DRAINAGE
to follow
areas pro
continues

Does
not appear
that we have
possible drainage
anywhere other than
away from the
Bldg.

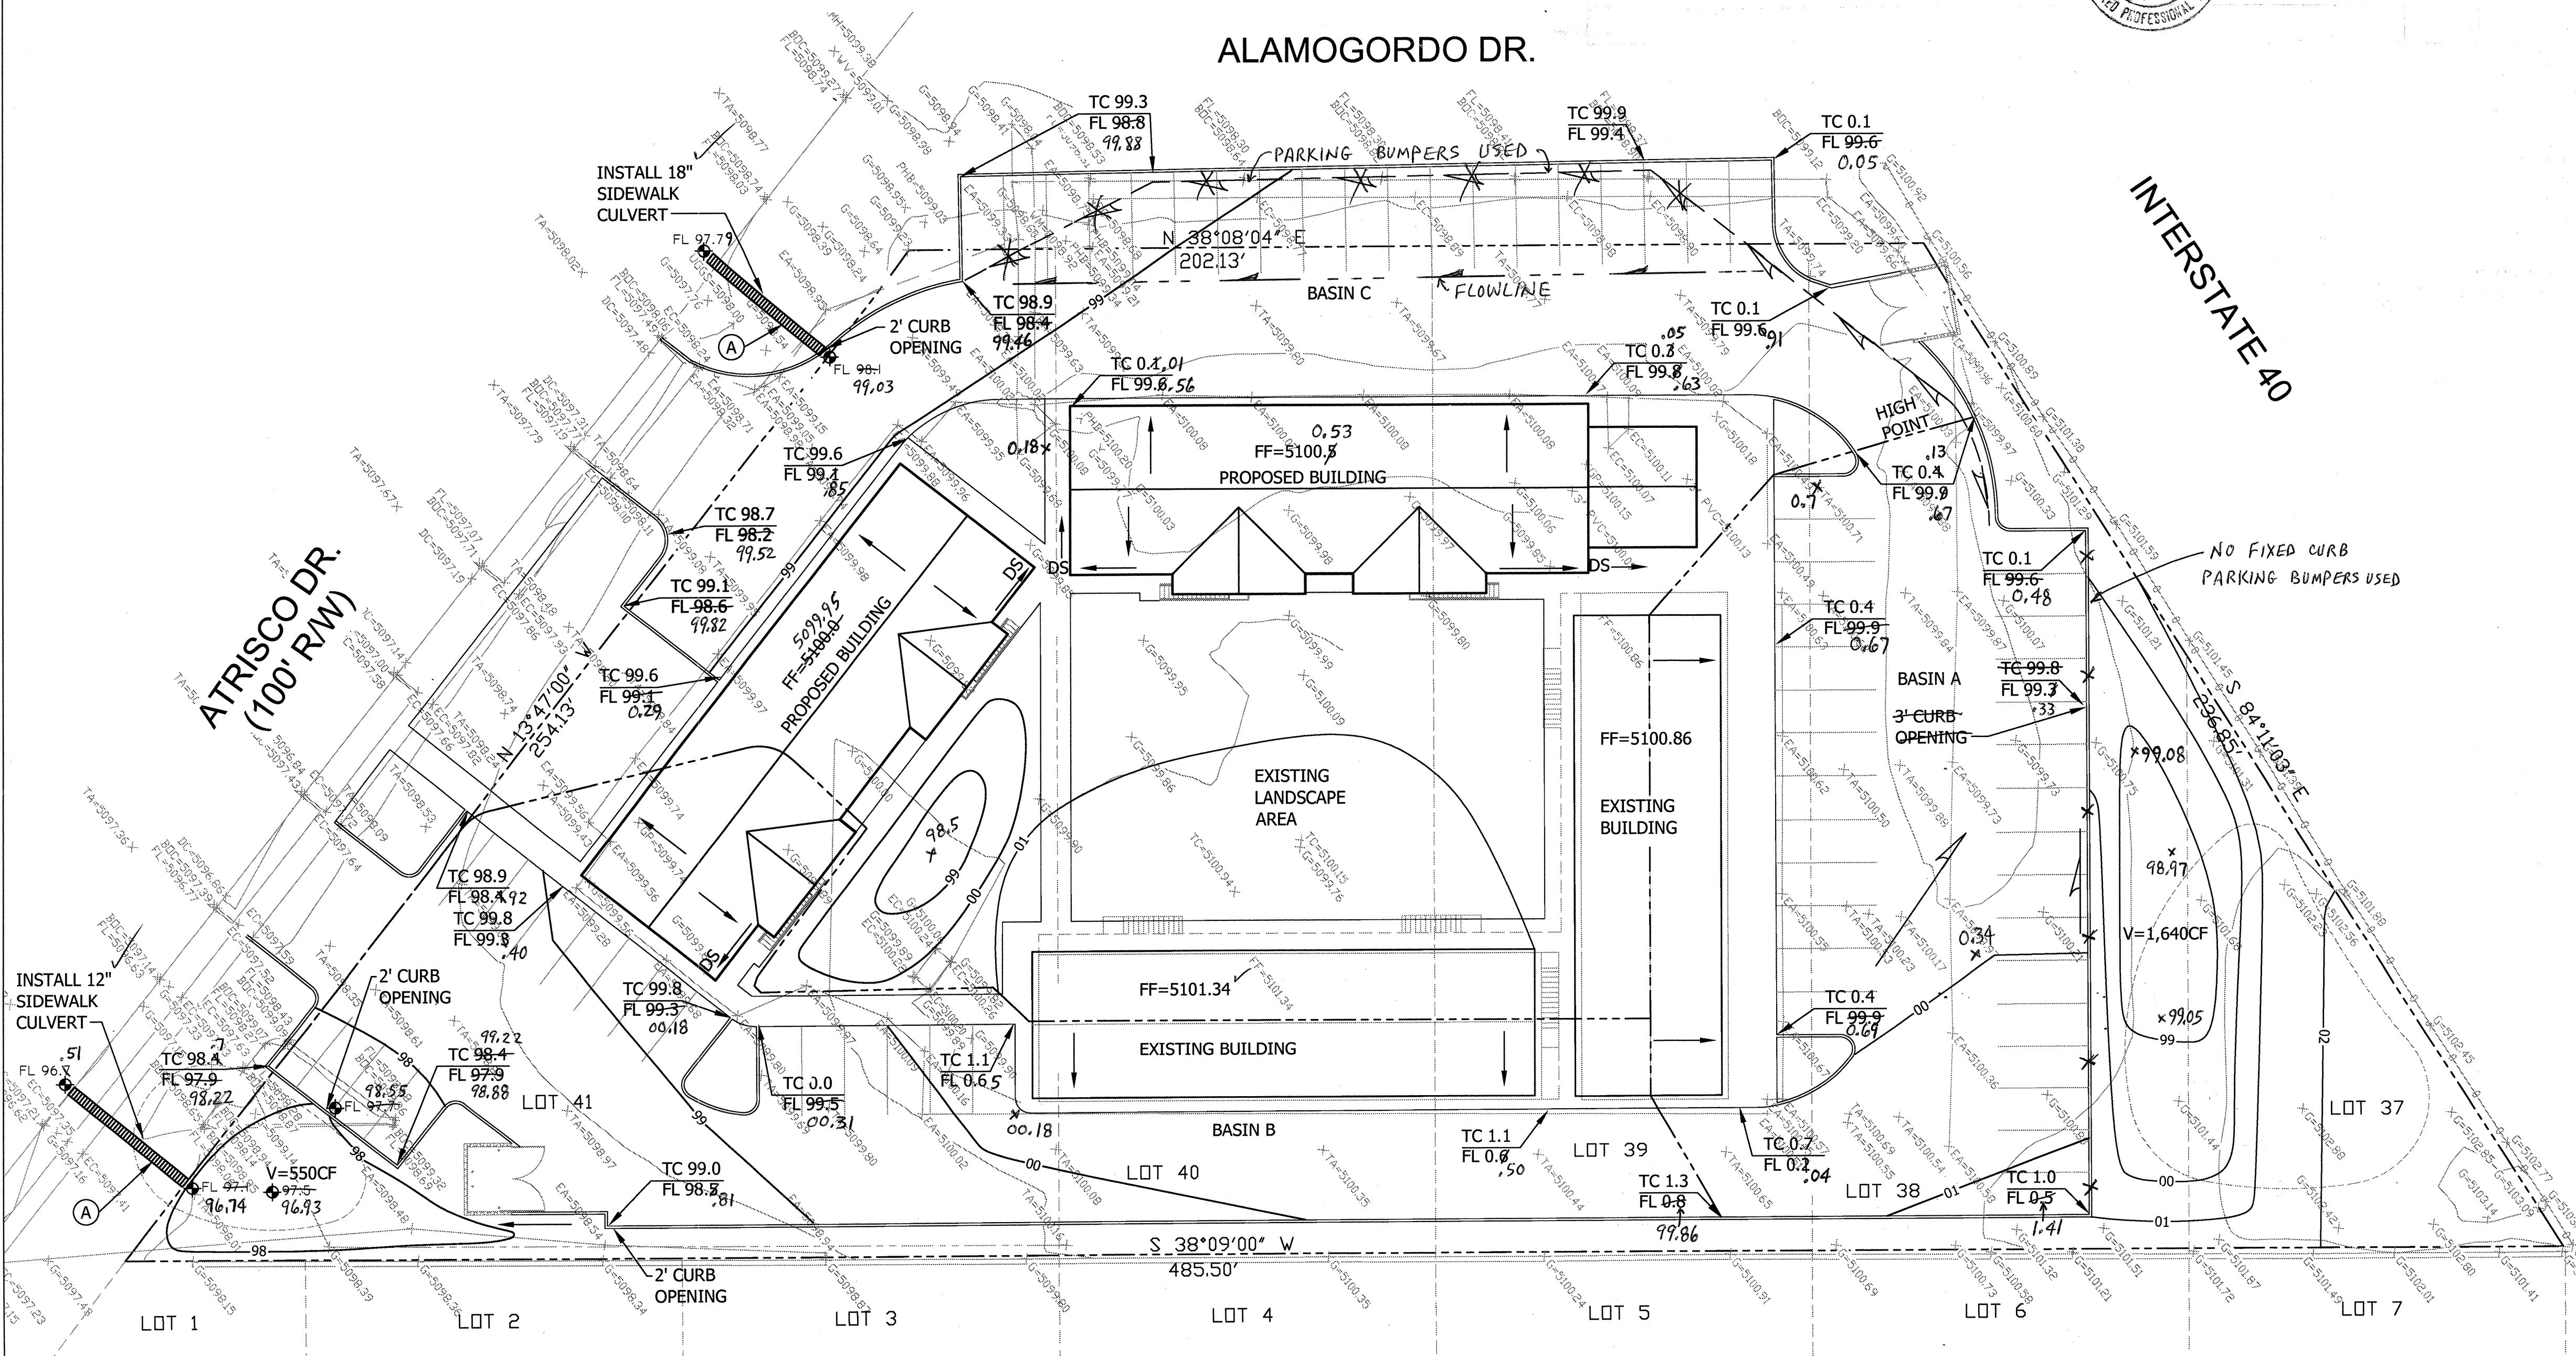
Provide curb opening

NO Positive
flow

NO FIXED CURB
PARKING BUMPERS USED
